**Date:** 08/29/2024

**Re:** **Framing Items**  
Location: Lot 92 Blakes Pond (122 Whembril Ct. (Lillington, NC))  
JDS Project No.: RDU2408909  
Date of Inspection: 08/29/24

1ST FLOOR FRAMING PLAN
SCALE: 1/8"=1'-0"

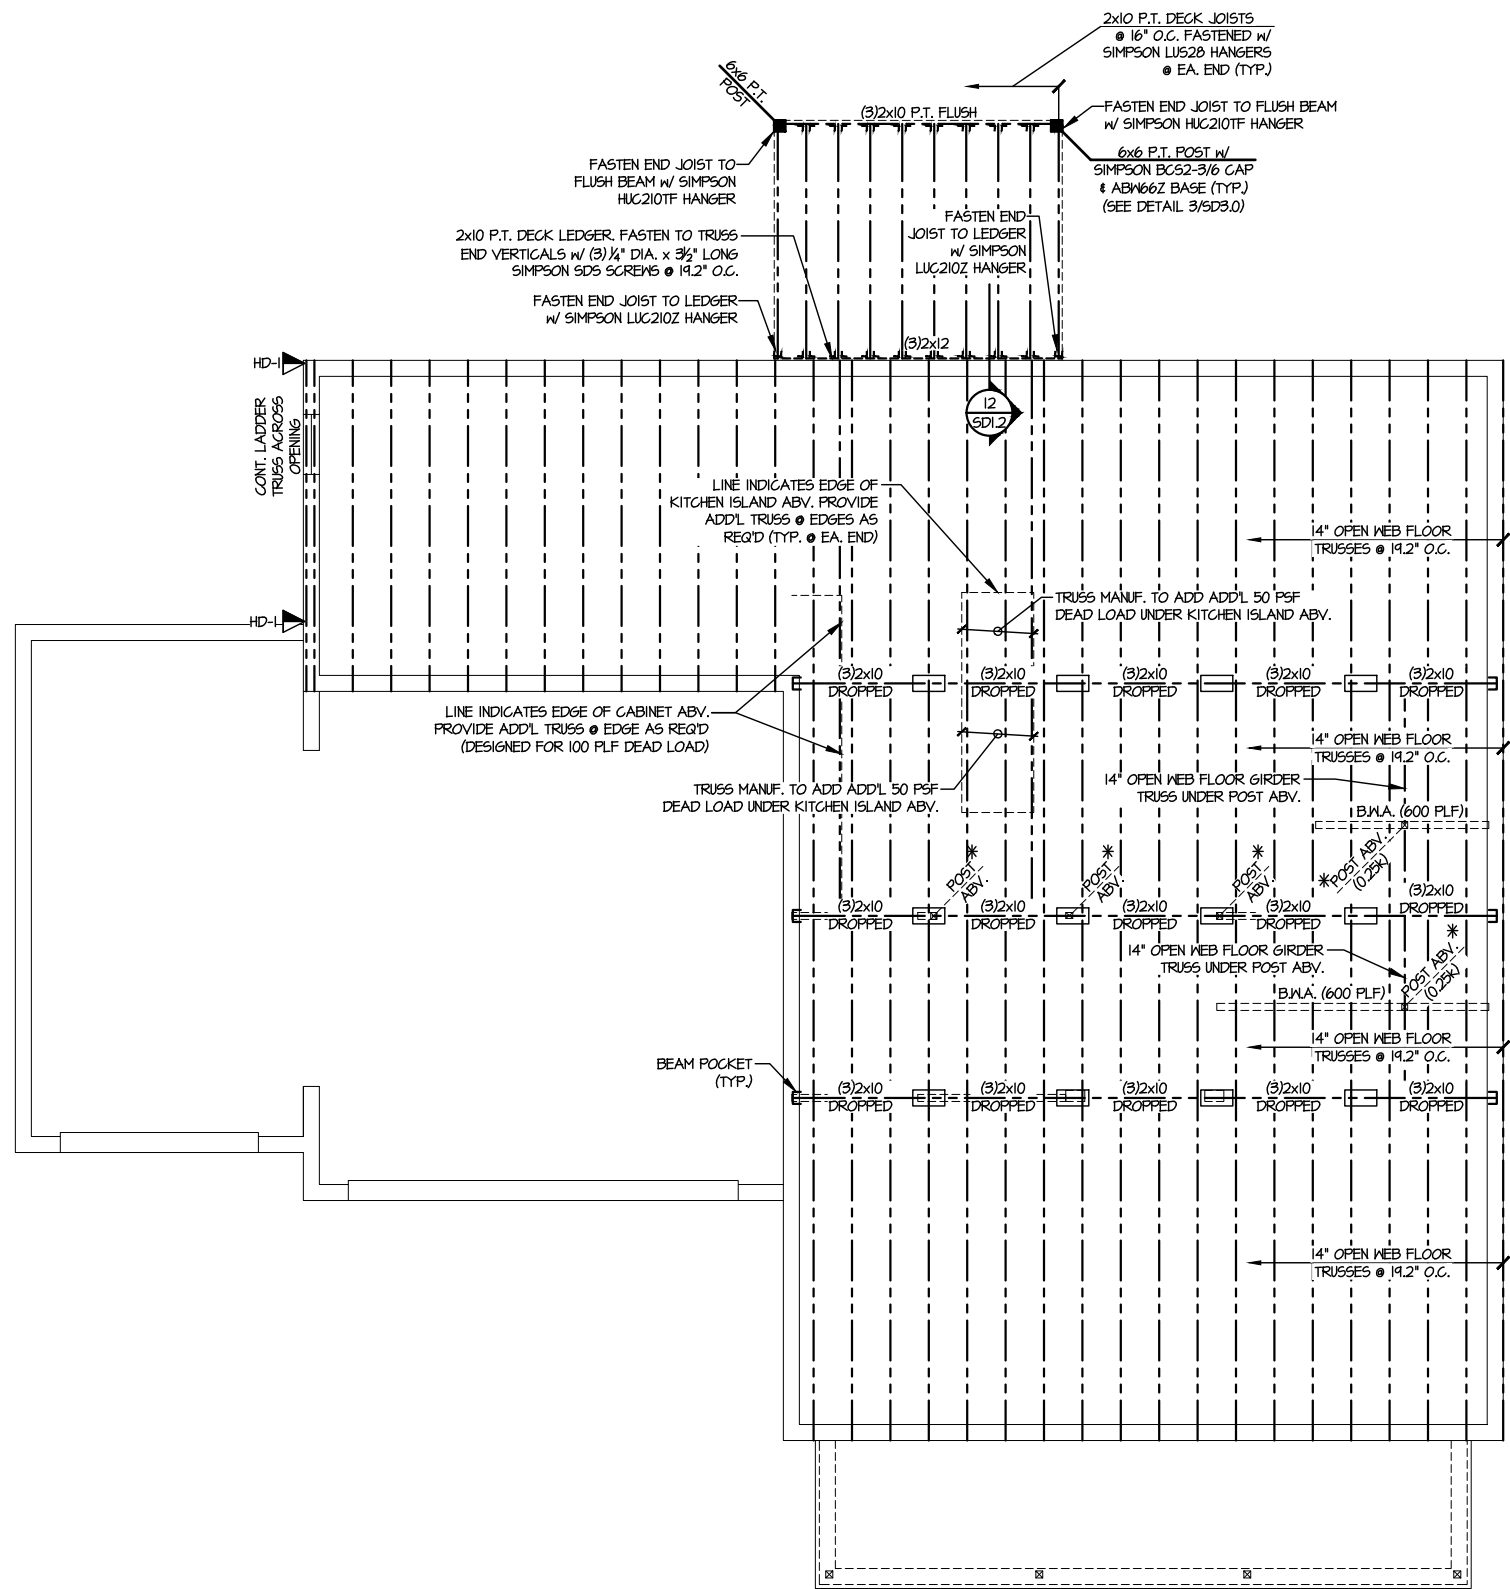
1. The rear wall windows to the right of the rear door have double 2x6 headers installed, plans call for double 2x8 headers.
2. The inspector is questioning the missing hangars on the stairwell landing joists. The stairwell landing joists have been ledgered on both sides.

1. The 2x6 headers are inadequate for the loading conditions, remove and install 2x8 headers over each window on the first floor at the rear wall to the right of the rear door as per plan.
2. The stairwell landing joists are adequate as installed and no further action is required.
